DECISION DELEGATED TO DEVELOPMENT MANAGER

Application No:	H09-0800-20	Applicant:	Mr J Jones
Proposal:	Erection of replacement bungalow		
Location:	Redwood Lodge 96 Dog Drove North Holbeach Drove		
Terminal Date:	17th November 2020

PROPOSED ELEVATIONS 1:100

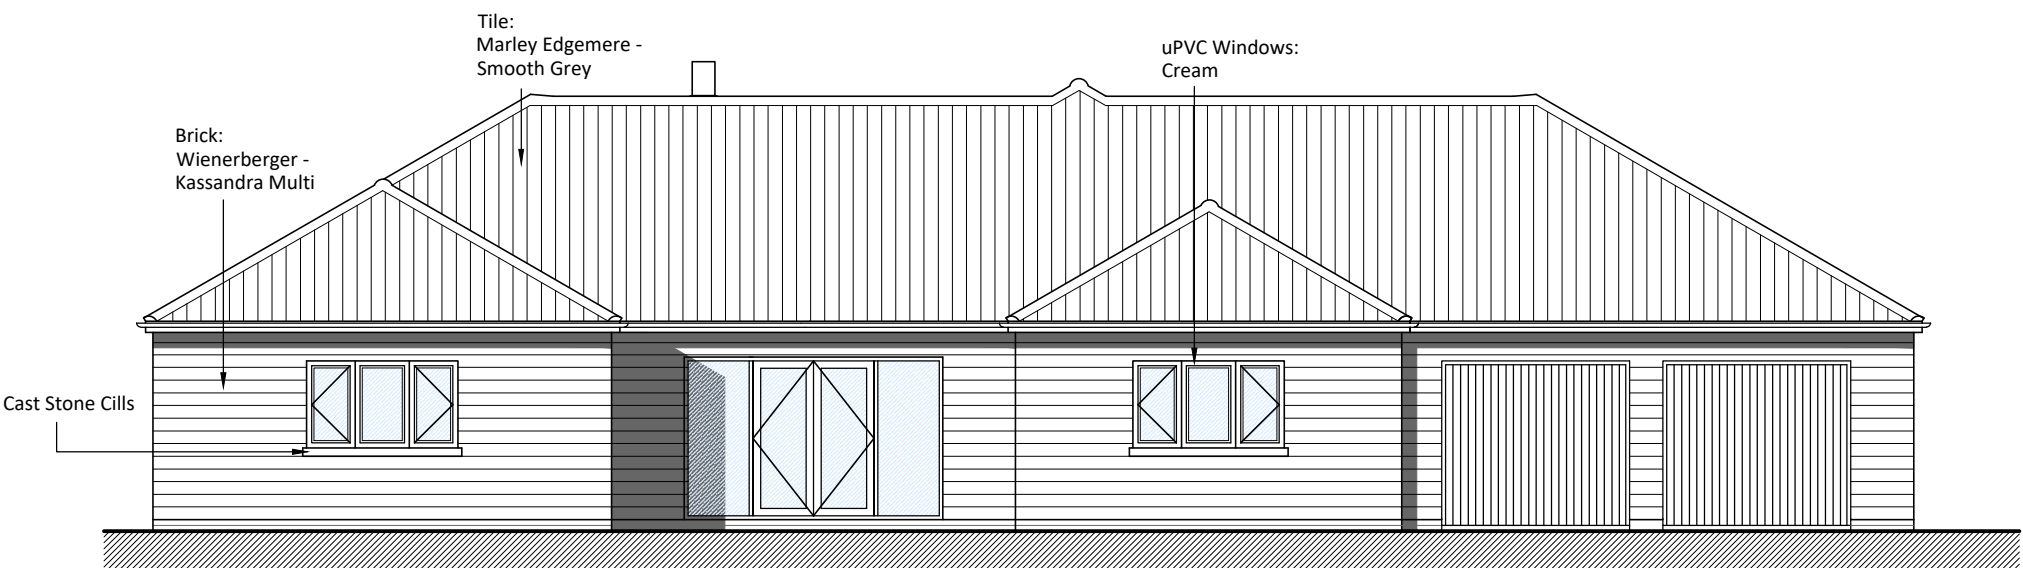
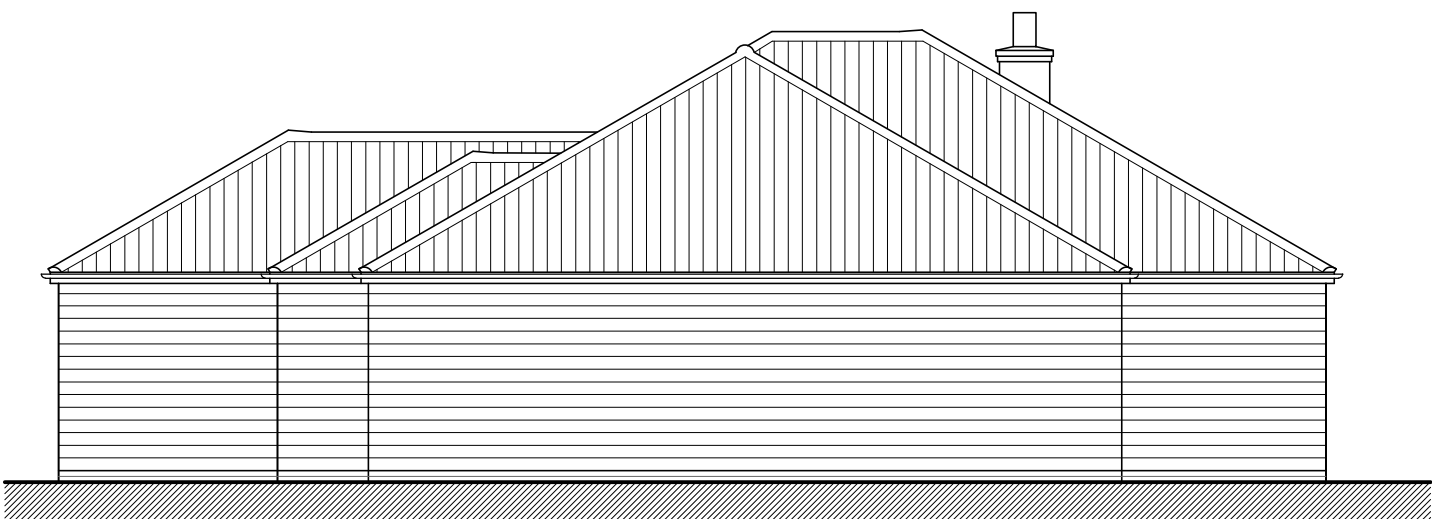
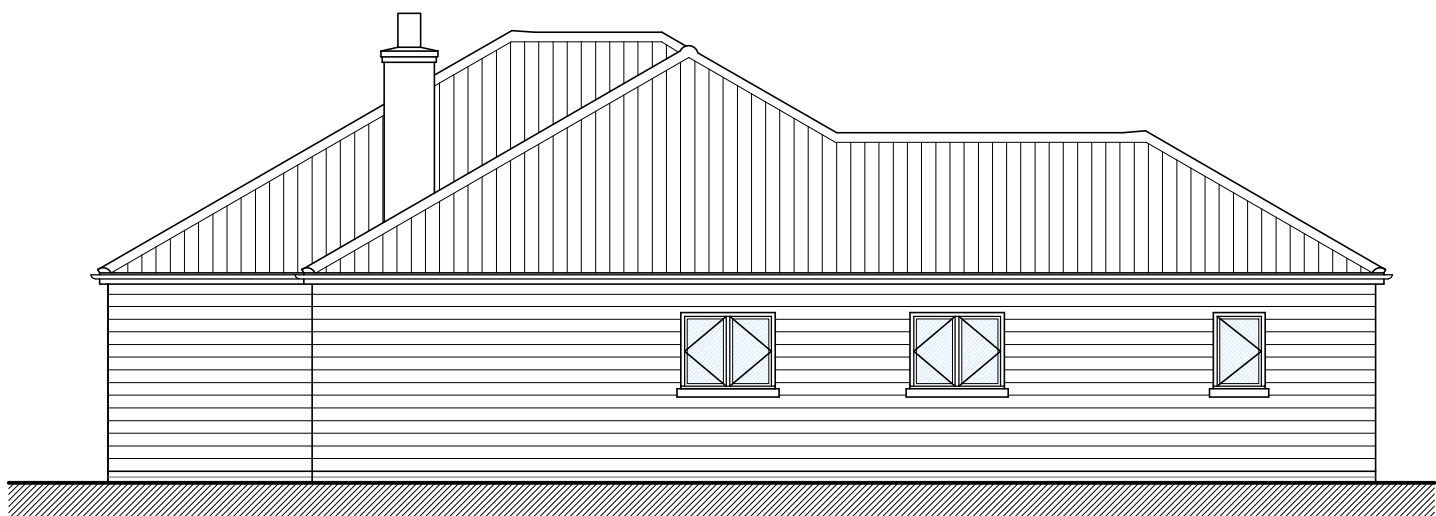
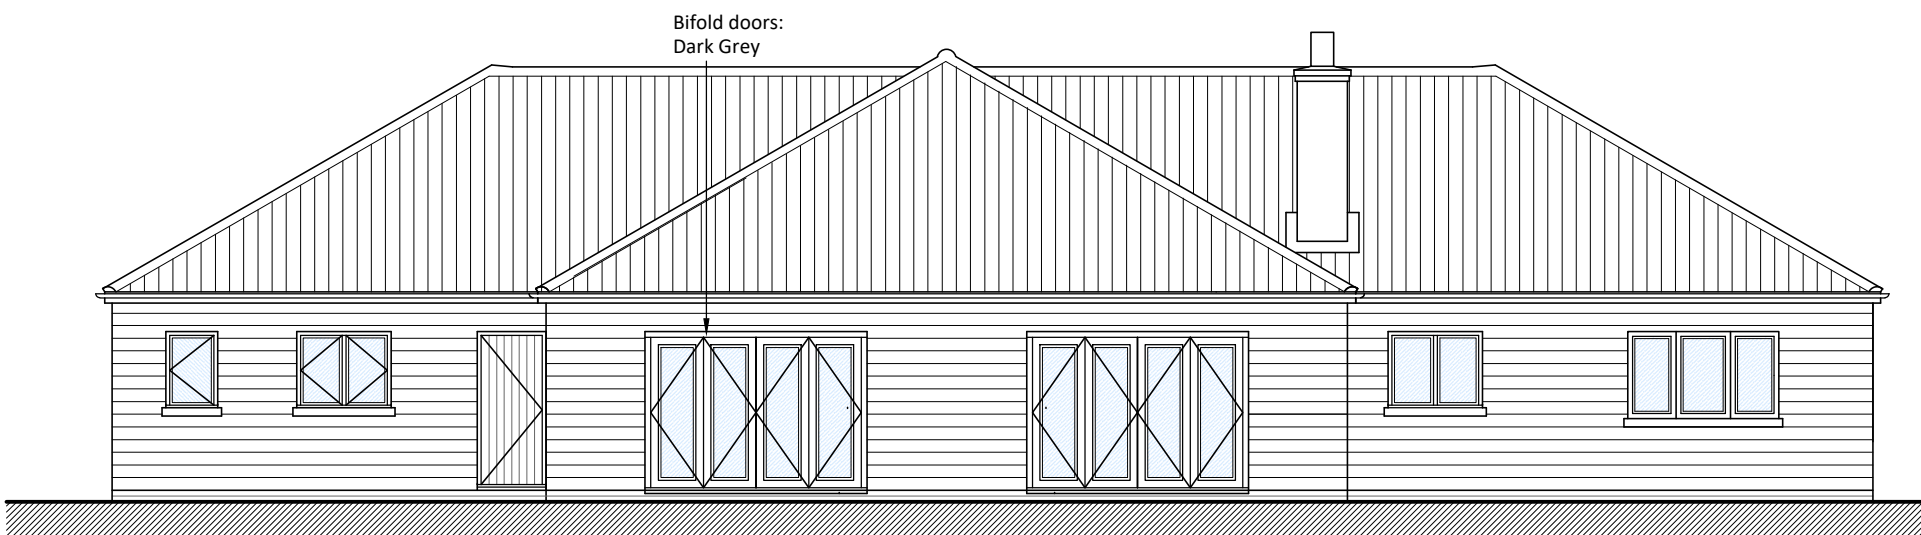
Concerning the fourth criterion, the proposed materials schedule is considered acceptable and in keeping with the character of the area. The proposed dwelling would be a bungalow tantamount with the building to replace. It is by no means considered that the proposed dwelling would be of low

The restricted height of the dwelling would not cause any impact upon the neighbouring properties in terms of overbearing impact. The form of the dwelling is of a bungalow tantamount to the type of the existing building. Mature hedge obscure views to the site from the adjacent locations.

SITE PLAN 1:500

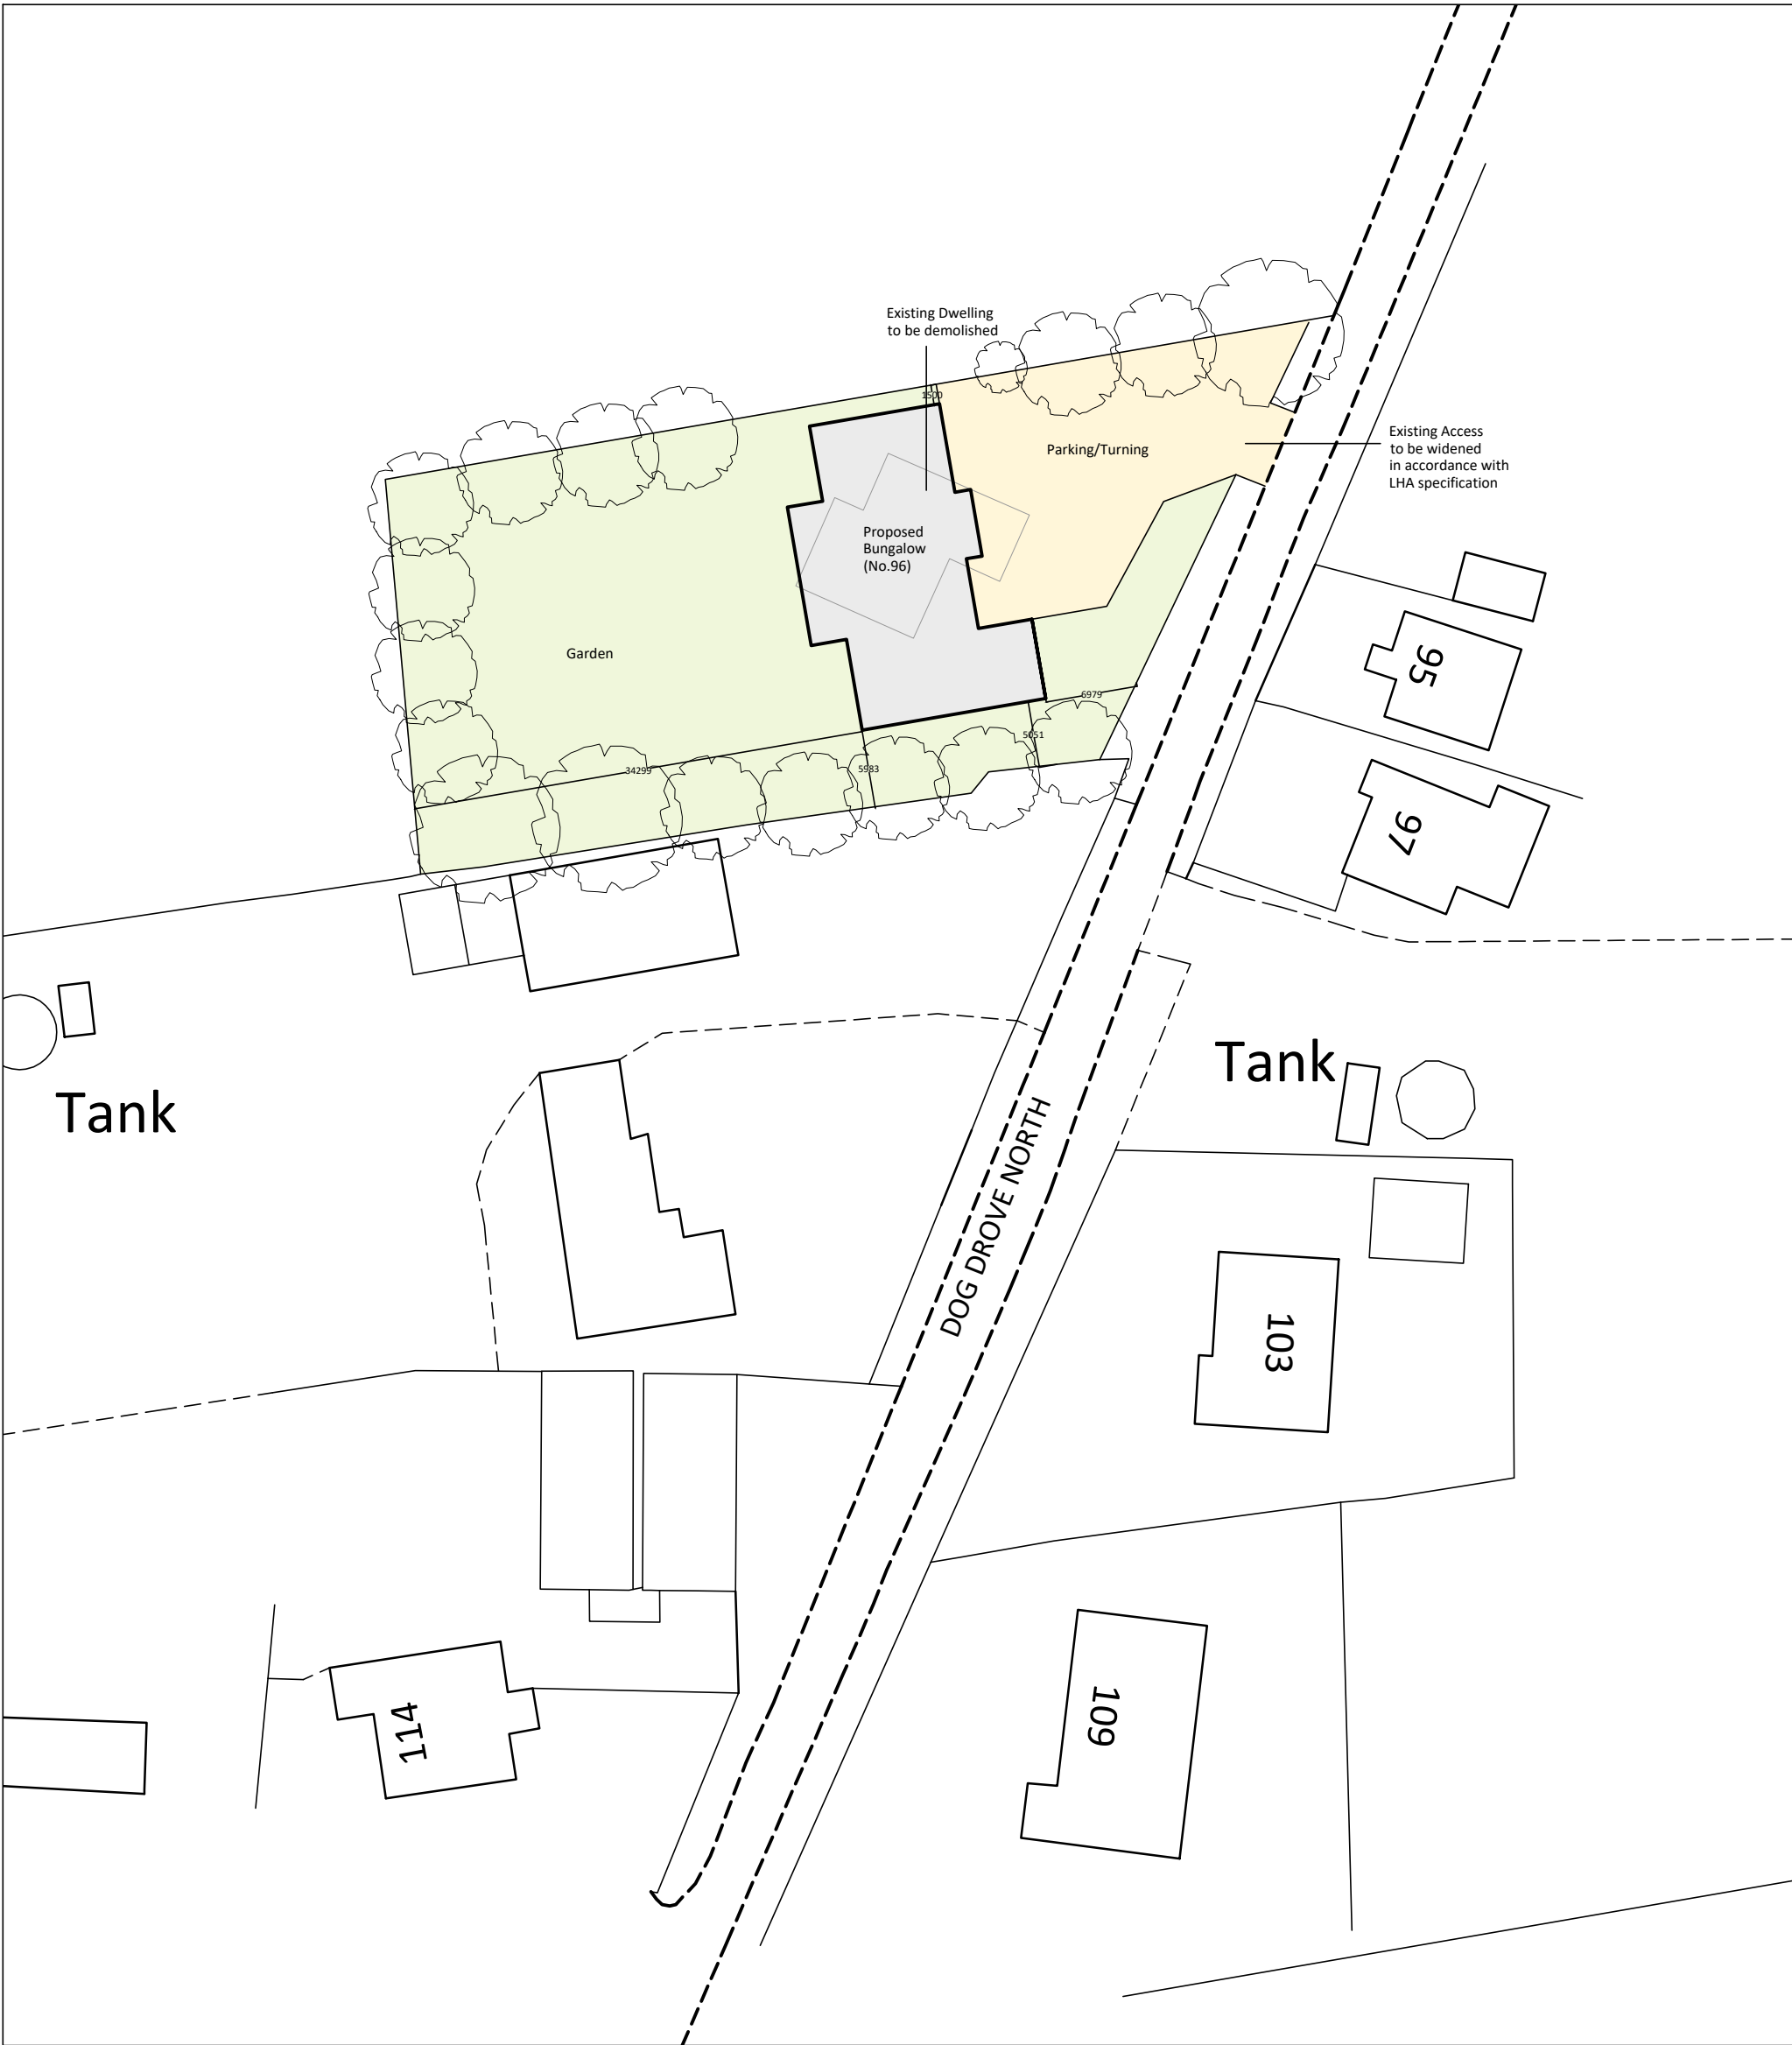
Turning into the fifth criterion, the proposed bungalow overlaps with approximately 85% of the original footprint. It might be considered that the replacement building is positioned on a similar footprint to the original building. However, the replacement dwelling will entail a re-position of the original building. The bungalow is currently set at an angle facing south-east whereas the replacement dwelling will be positioned slightly facing north-east. Additionally, the proposed footprint will be larger than the original footprint of the bungalow. No evidence has been raised to demonstrate the benefits of such alterations.

In respect of the sixth criterion, the footprint of the replacement dwelling will approximately amount to 292.14 sq. metres and the footprint of the current bungalow, roughly 129.23 sq. metres. 40% of the floor area of the original dwelling is 51.69 sq metres. Once this amount is added up to the total floorspace of the existing dwelling, the number raises up to 180.92 sq metres which is the maximum amount for a replacement dwelling. The footprint of the new dwelling (292.14 sq. metres) clearly exceeds the maximum floorspace allowed (180.92 sq metres).

It is assumed from the block plan that mature hedge on the front boundary will be removed. The resident representation has made reference to some potential overlooking from the bedroom window to the properties opposite the road. The shortest separation with No. 95 will be in the region of 24.65 metres. At such distance, no unacceptable overlooking will occur.

The proposed dwelling will have 4 bedrooms. Three spaces for dwellings with 4 or more bedrooms should be provided within the curtilage. The parking area shown on the block plan appears to accommodate such number of spaces although they have not been marked.
